Online Comment

Application H17-0556-26
Location IVY HOUSE GOSBERTON BANK GOSBERTON PE11 4PB
Proposal Proposed Sun Room to rear of dwelling with internal wall removal.

Name Gregory Watkinson, Principal Conservation Officer
Address Council Offices Priory Road Spalding PE11 2XE

Date Submitted 24-07-26
For/Against Comments

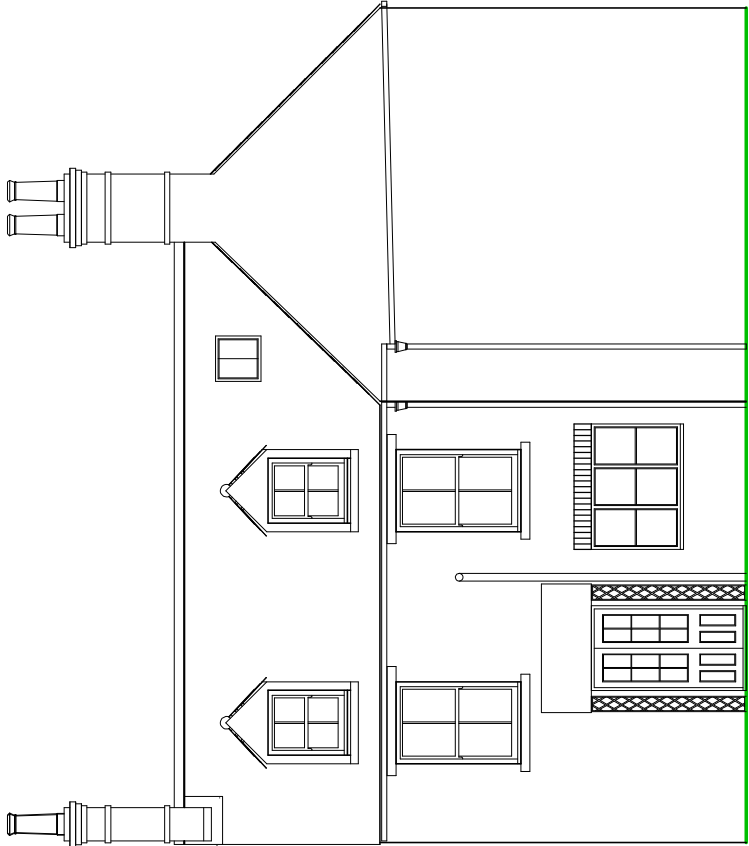
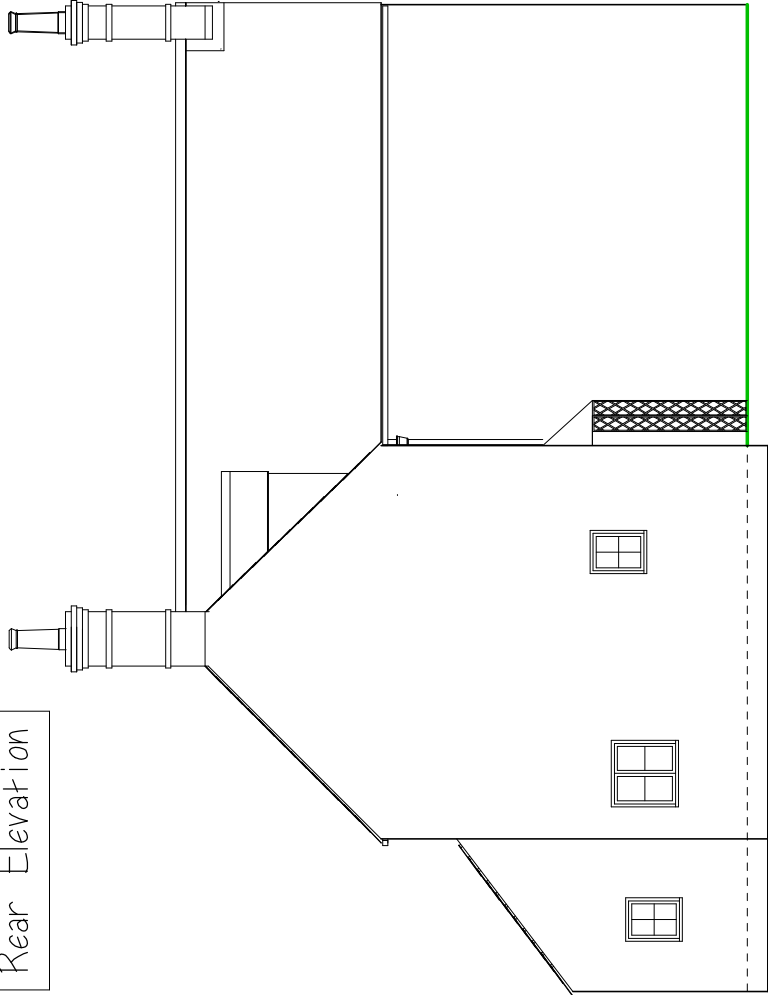
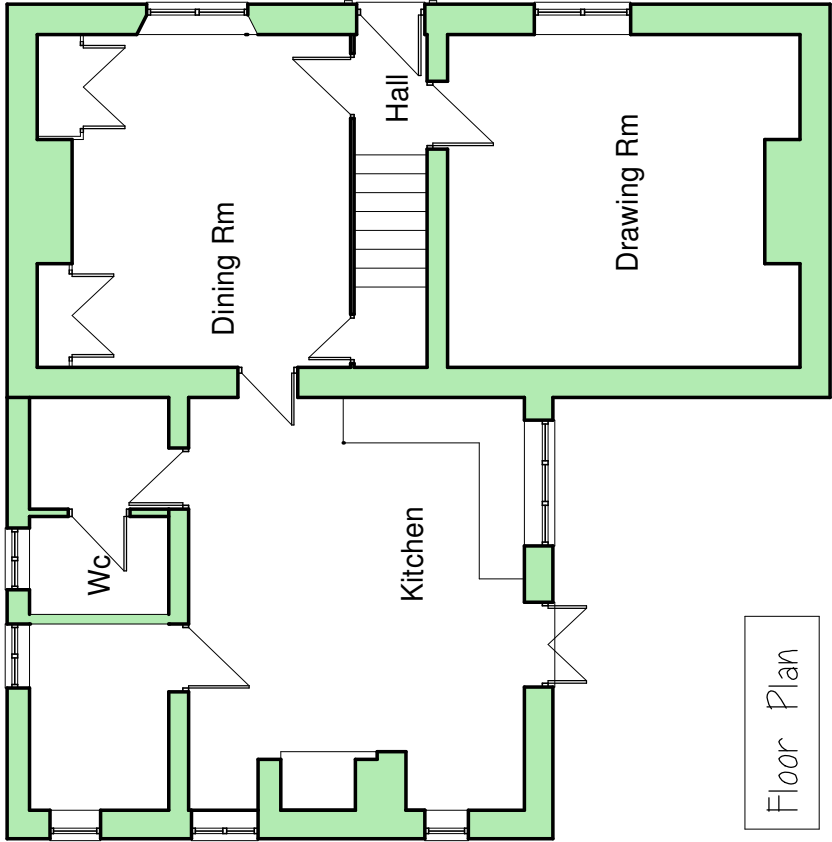
Firstly, I believe that the northwestern elevation can and should be brought out to sit flush with the side elevation of the property. As it stands, the proposal seeks to create a relatively awkward building geometry with multiple nooks and angles. By pushing out this elevation, it creates a less visually confused development without compromising on size.

Moreover, I would recommend that the windows be changed from side opening casements with a central meeting rail to a 2 over 2 sliding sash window. During the course of the previous application on site (refused) we discussed how several of the features that the applicant intended to utilise on their proposed extension were inappropriate features borrowed from the 1990s/early 2000s restoration work; this includes the casements which are not period appropriate to this building and less than ideal. I find it doubtful that should that be presented to the LPA today that the LPA would be satisfied by the introduction of such casements into the host building, and therefore, there is no reason, nor justification to permit them to be proliferated into an extension.

Moreover, I will need to see more detail of the proposed coping for the parapet (which should be authentic carved stone or possibly leaded), as well as full details of the proposed rainwater goods. It appears that the applicant proposes to make use of the existing RWGs on the rear elevation, but no details of this system are provided and nor are any elevation details presented for that return elevation - these must be provided.
